Historic England

14 April 2016

**BUILDINGS 485, 488 AND LAND SURROUNDING THOSE BUILDINGS (DORCHESTER PHASE 6) HEYFORD PARK CAMP ROAD UPPER HEYFORD
Application No 16/00263/F**

Figure 1: Building 485

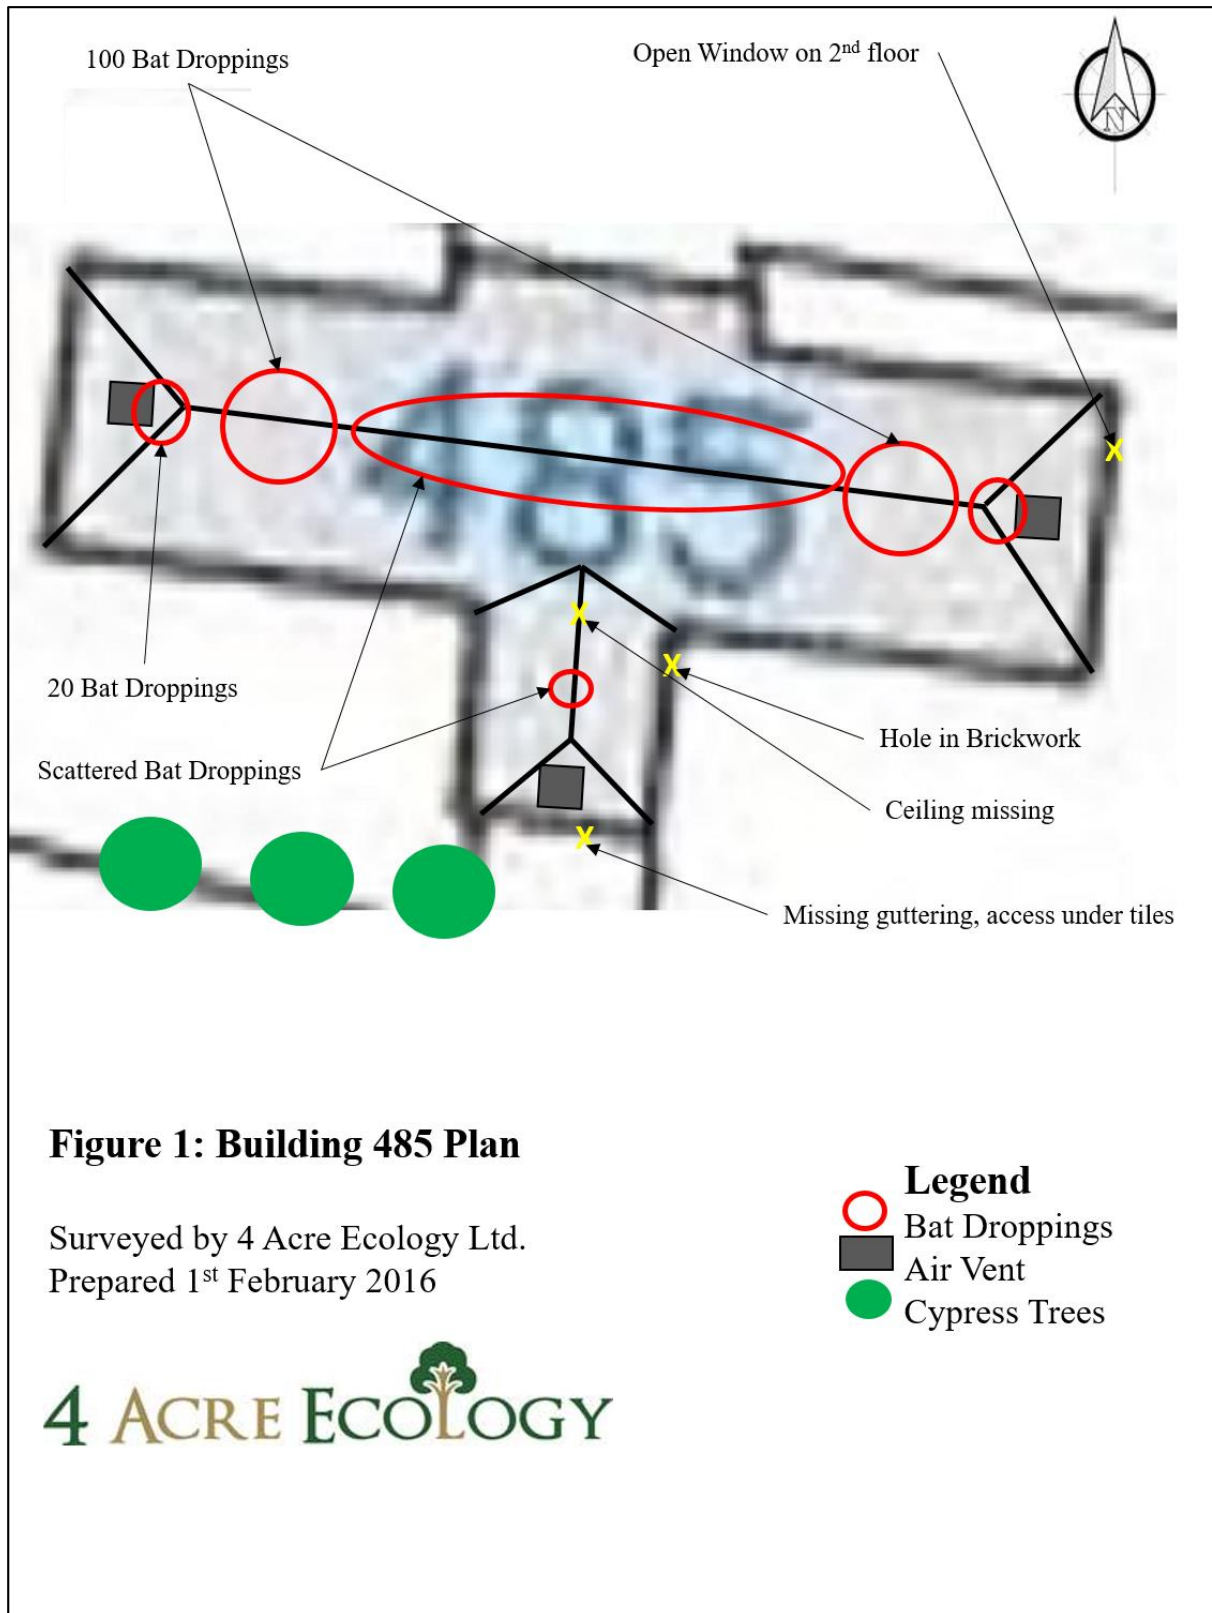
This application includes the demolition of Buildings 485 and 488 on the domestic part of the Upper Heyford site. Building 485 is a type B barrack block constructed in 1837 as part of the first phase of development on the site following re-occupation by the RAF in 1924. It stands at the south end of the parade ground and was identified in the Conservation Area Appraisal (2006) as making a positive contribution to the character of the area due to its value as part of a coherent group of 1920s buildings in the British Military style surrounding the parade ground. The appraisal recognised the strong building lines and campus quality of the parade ground area. This set of buildings are also of historical interest as Upper Heyford was the first of the interwar RAF airfields to be constructed and the buildings and layout served as a model for those that came later.

The loss of these buildings would clearly harm the significance of the Conservation Area. While the defining characteristic of the Conservation Area is as a Cold-War airbase its early occupation by the RAF is an interesting aspect of its history. The buildings in question are among the more interesting and better preserved of the survivors from this phase on the site and therefore we conclude that their loss would entail a high, but not substantial, level of harm. In our view the Planning and Heritage Statement submitted in support of this application underplays the interest of these buildings and overplays the impact of alteration that have been made to them, leading to an underassessment of their significance. According to paragraph 132 of the NPPF *any* harm to a designated heritage asset (which includes Conservation Areas) requires a clear and convincing justification whilst paragraph 134 of the Framework requires harm to be balanced against the public benefits of the application. Furthermore, section 72 of the Planning (Listed Buildings and Conservation Areas) Act, 1990 requires Local Authorities to pay special attention to the desirability of preserving or enhancing the character or appearance of that area.

English Heritage recommend that this application is refused on the basis that a robust justification for the harm to the Character of the Conservation Area that the proposals entail has not been provided. The Council should only accept this level of harm if a clear case is made that implementing the masterplan set out in the permitted application 10/01642/OUT is not practical.

Figure 2: Building 488

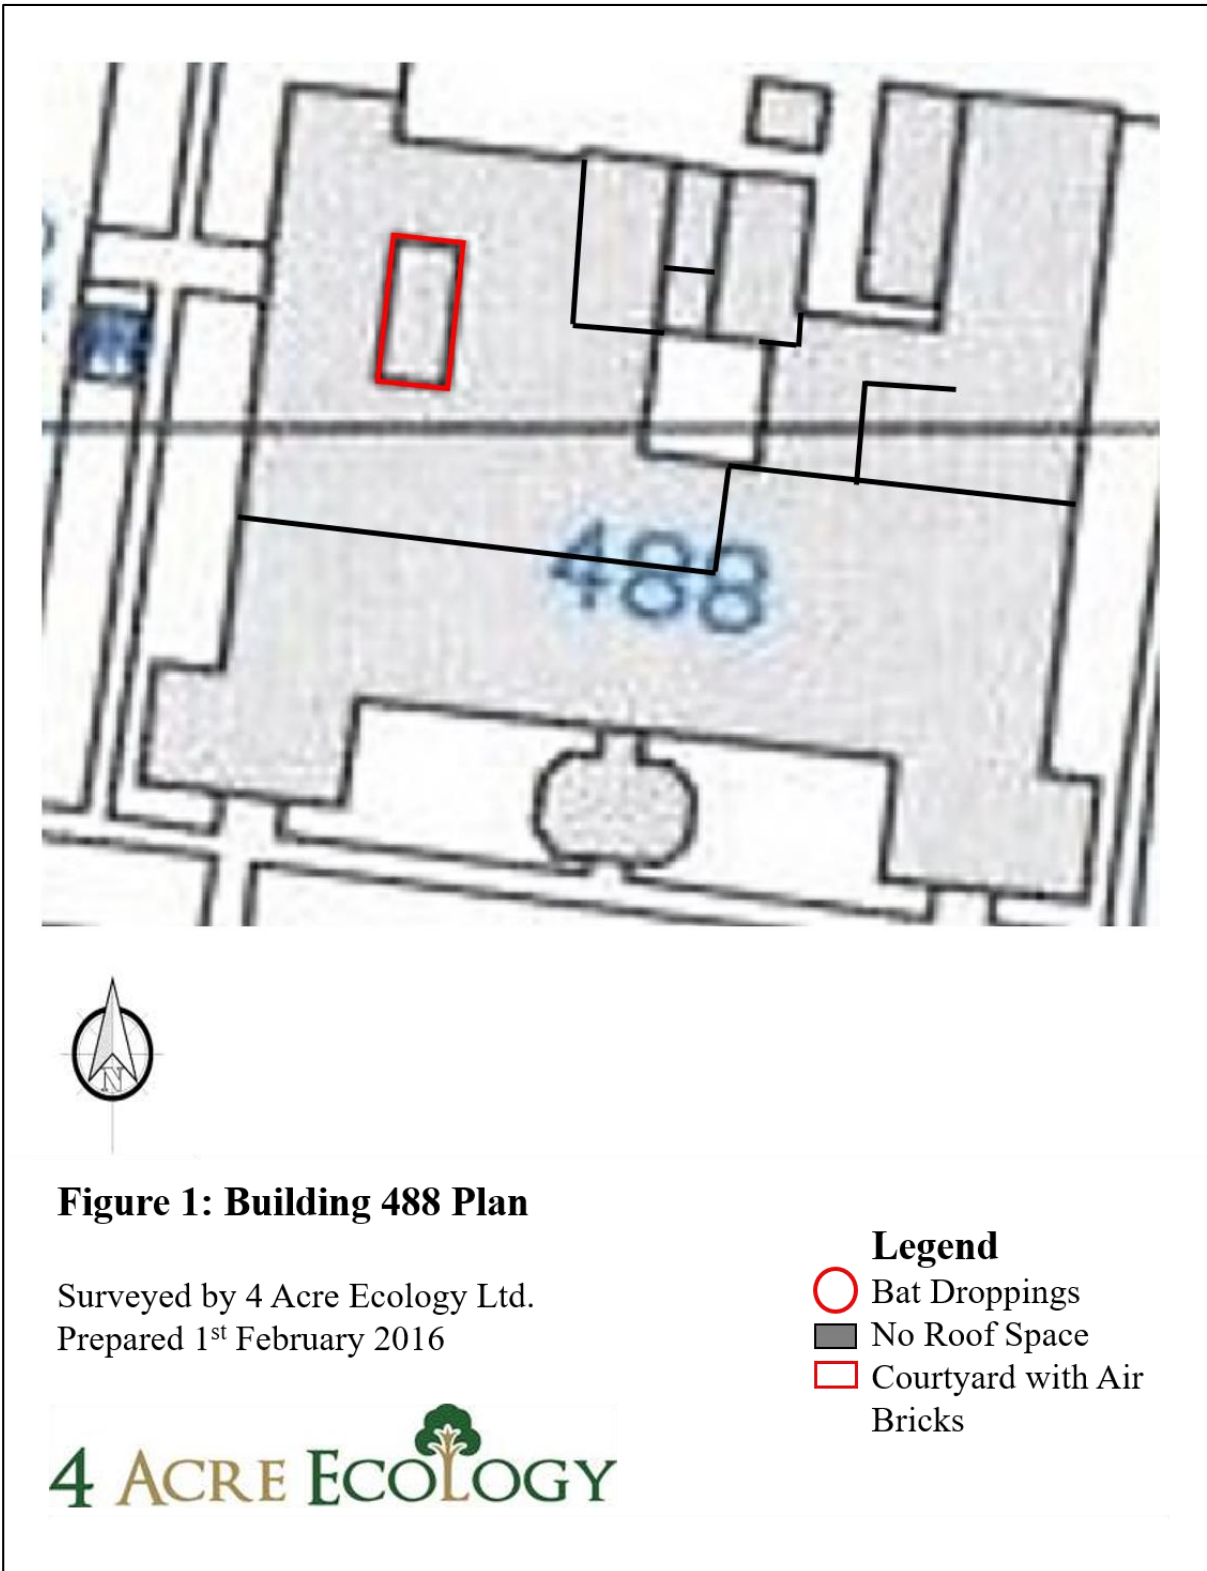
Building 488, the Airman's Dining Room and Institute, is slightly later and forms part of

the expansion of the RAF base in the 1930s. This is also identified as a positive contributor in the Conservation Area Appraisal which notes its Art Deco styling and its coherent character with the H-blocks (buildings 489, 498 and 500), though this has been diluted by post-war alterations and additional buildings. We concur with the conclusions of the Appraisal and regard these buildings as good examples of their type which help tell the earlier history of the base, form a coherent group and thus contribute to the significance of the conservation area.
